# BCA COMPLIANCE ASSESSMENT REPORT

## Building Code of Australia 2022 Amendment 2

PROJECT: 461 Chapel Road, Bankstown  
REF. No.: NEW241003 (Rev 4)  
DATE: 27/02/2026  
CLIENT: Sustainable Development Group  
CONTACT: Richard Huynh  
EMAIL: richard.huynh@sdg.org.au  
CONSULTANT: Mauricio Vera  
PHONE No: 0451 078 790  
EMAIL: mvera@newcrown.com.au

Level 1 - Floor Plan

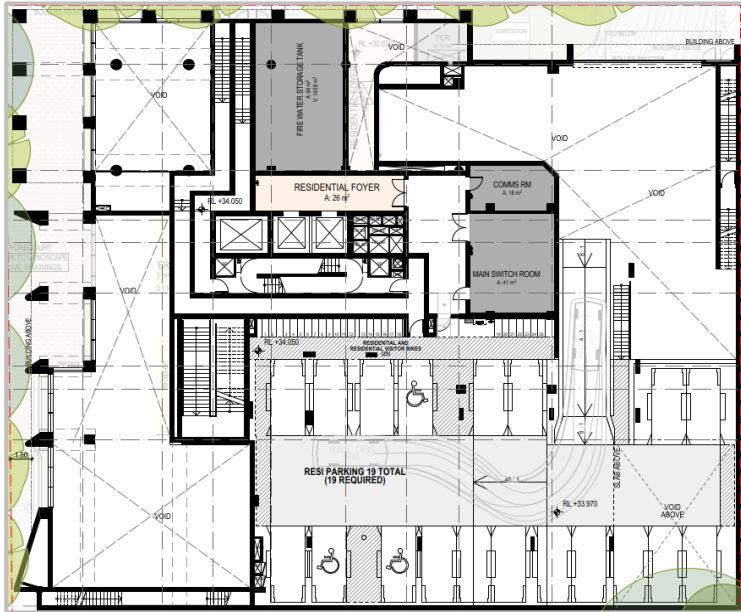
3.	Absence of FRL at base of a fire rated shaft (garbage chute).	Performance Solution	C1P1, C1P2	C2D2, S5C8	TBC
4.	Insufficient exits of one (1) in lieu of two (2) in level 1 childcare part	Performance Solution	DIP4, E2P2	NSW D2D3 (4) (iv)	TBC

6.	Excessive travel distances of 80m in lieu of 60m between exits (ground floor)	Performance Solution	DIP4, E2P2	D2D6	TBC
7.	Insufficient egress width of less than 1m identified in various locations (Level 1)	Design rectification	DIP4, E2P2	D2D8	TBC
